YorkshireWater

**Your Ref: 2026/0480
Our Ref: B/01838**

17th August 2026

66 Longley Street, Barugh Green, Barnsley, S75 1NT - (BARNS) - Erection of a detached bungalow (Custom/Self-Build) and associated works including subdivision of residential garden; alterations to parking arrangements and retrospective changes to the external elevations of the host dwelling (Revised Description)

A	EXISTING AND PROPOSED SEWERS SHOWN ON PLAN. ROOF HATCH UPDATED FOR PROPOSED PLOT.	29.07.26
REV	DESCRIPTION	DATE
DEVELOPMENT		
LAND ADJACENT TO 66 LONGLEY STREET, BARUGH GREEN		
DRAWING TITLE		
PROPOSED SITE LAYOUT		
DATE	25.04.26	SCALE 1:250@A3
DRAWN	WS	
DRAWING REF	LS-NB-PSL-01	REV A

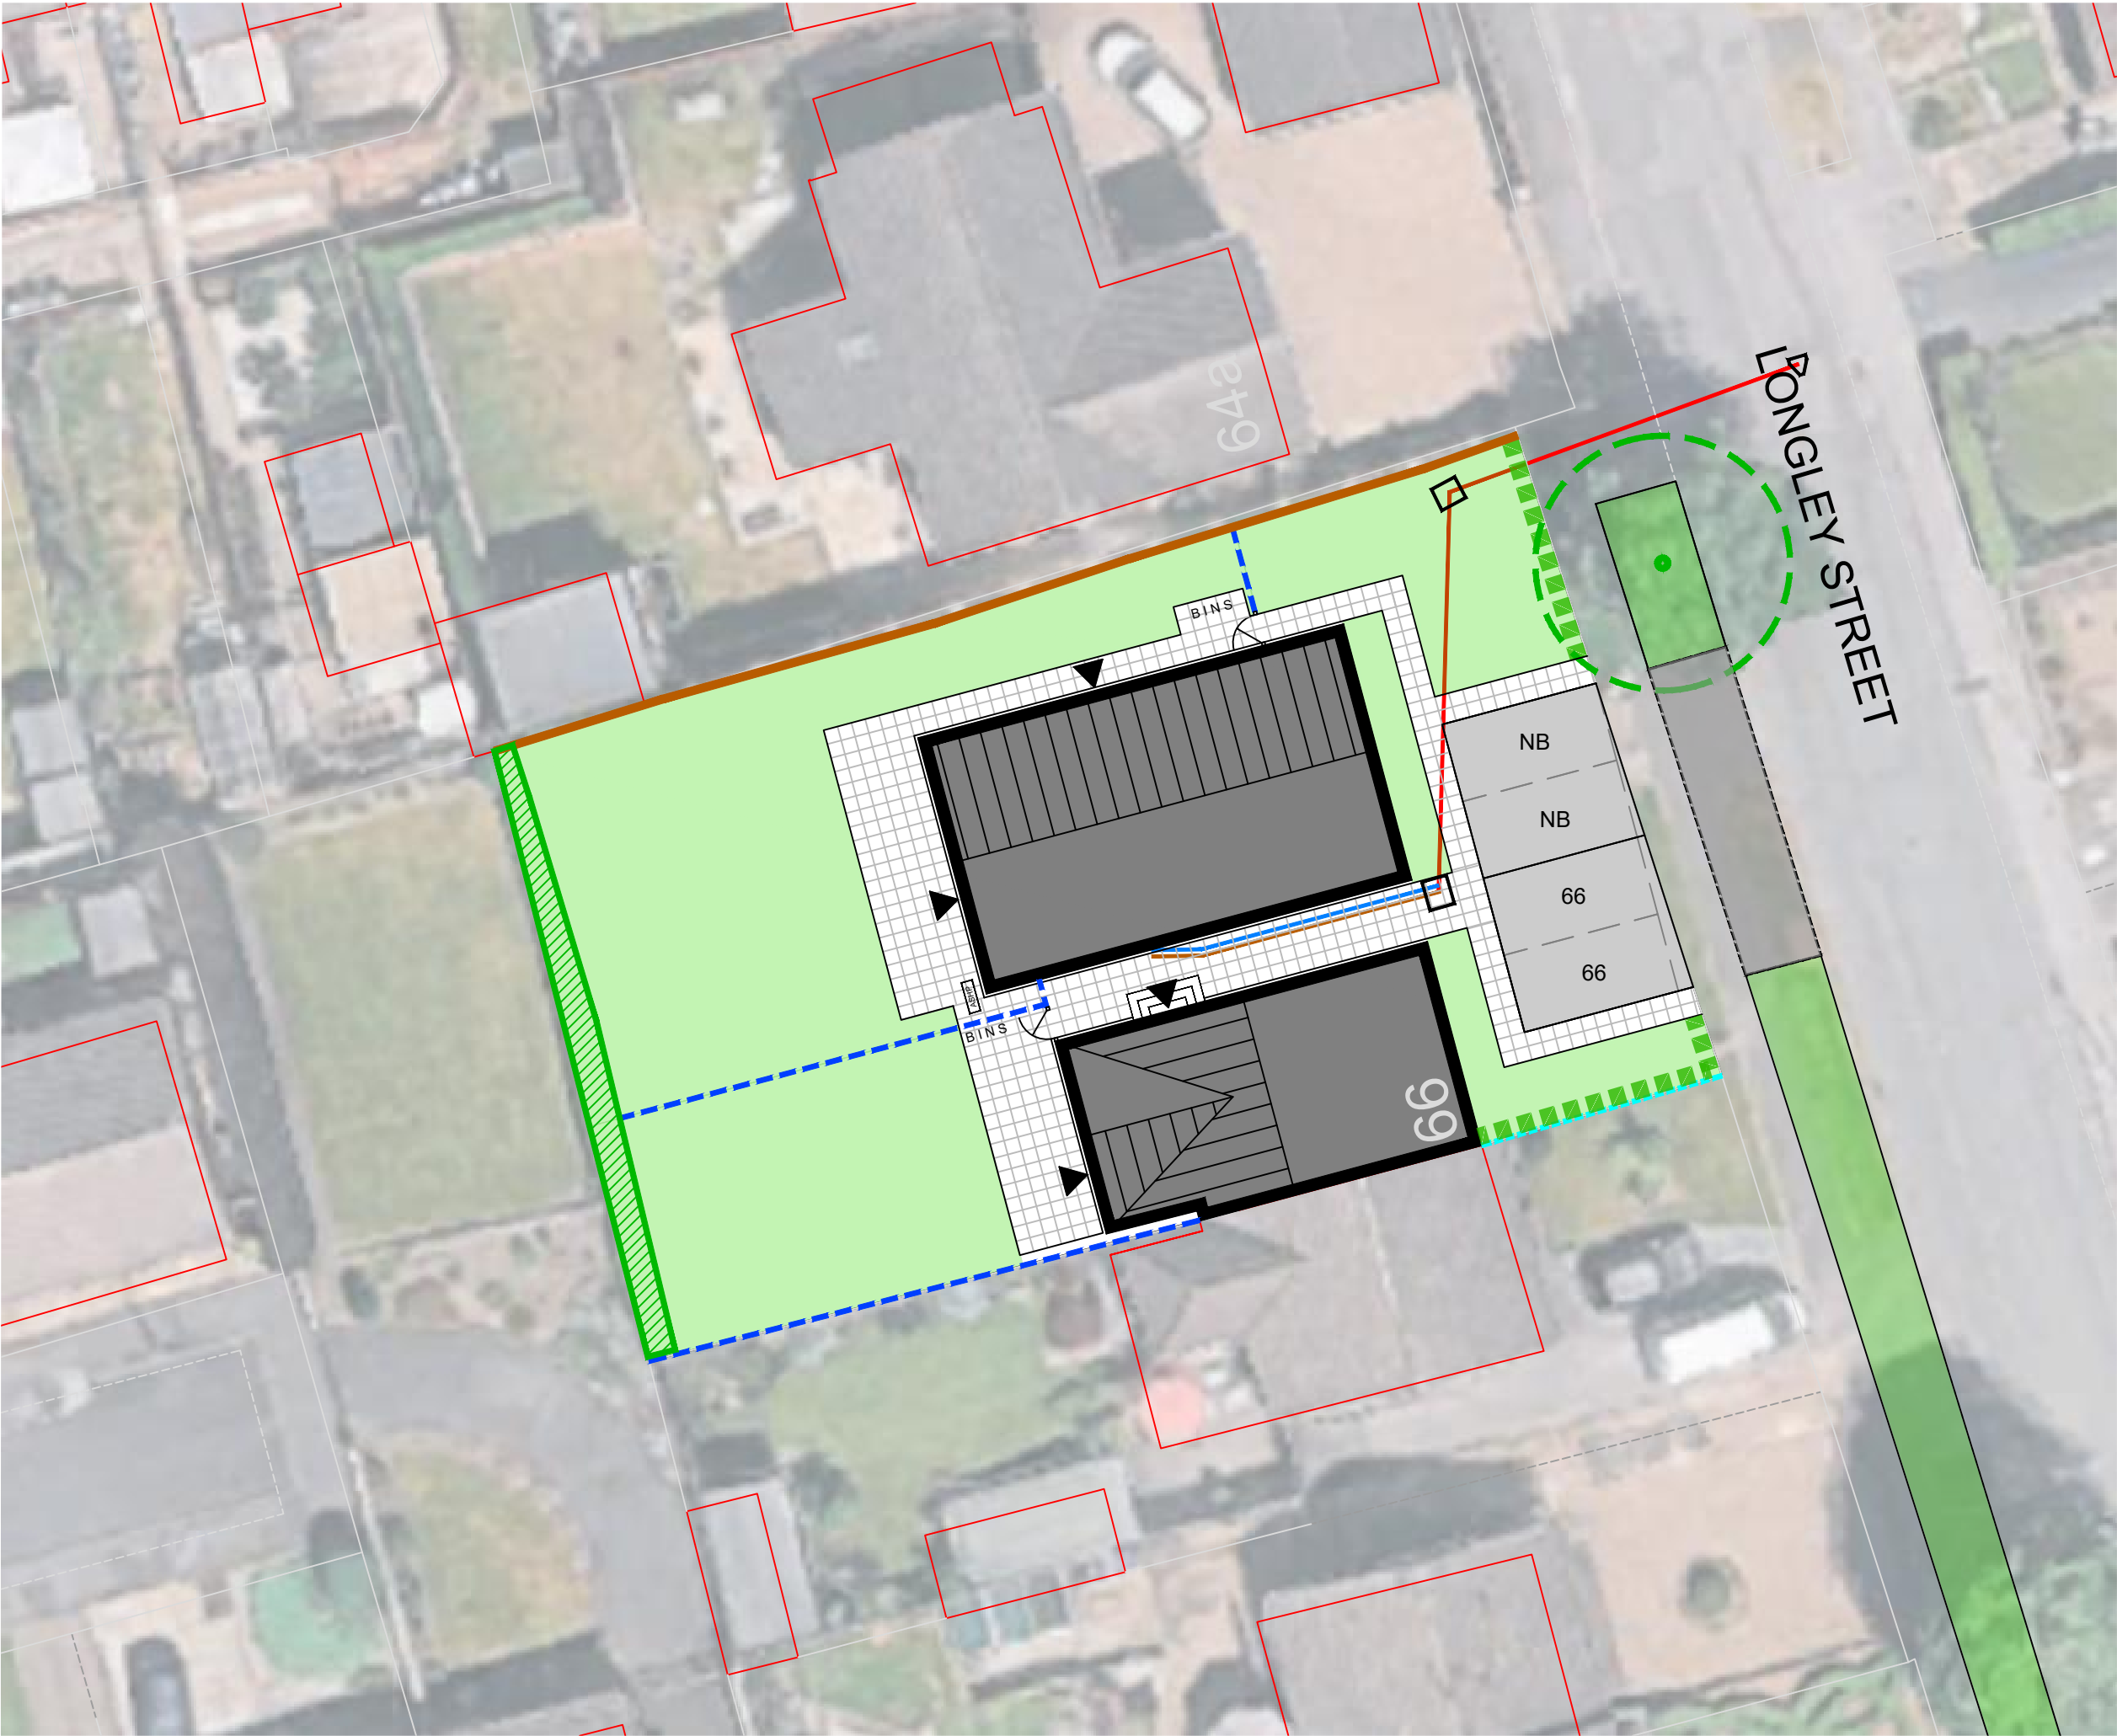
Development of the site should take place with separate systems for foul and surface water drainage. The separate systems should extend to the points of discharge to be agreed.

The developer is proposing to discharge surface water to public sewer however, sustainable development requires appropriate surface water disposal.

Yorkshire Water promote the surface water disposal hierarchy, and the developer must provide evidence to demonstrate that surface water disposal via infiltration or watercourse are not reasonably practical before considering disposal to public sewer.

As the proposal site is currently undeveloped, no positive surface water is known to have previously discharged to the public sewer network. Surface water discharge to the existing public sewer network must only be as a last resort and the developer is required to eliminate other means of surface water disposal.

As a last resort, and upon receipt of satisfactory evidence to confirm the reasons for rejection of other methods of surface water disposal, curtilage surface water may discharge to public sewer at a restricted rate not to exceed 3.5 litres per second.

The site shall be developed with separate systems of drainage for foul and surface water on and off site. The separate systems should extend to the points of discharge to be agreed, details of which will have been submitted to and approved by the Local Planning Authority.

There shall be no piped discharge of surface water from the development prior to the completion of surface water drainage works, details of which will have been submitted to and approved by the Local Planning Authority. If discharge to public sewer is proposed, the information shall include, but not be exclusive to:

- i) evidence that other means of surface water drainage have been properly considered and why they have been discounted; and**
- ii) the means of discharging to the public sewer network at a rate not to exceed 3.5 litres per second.**
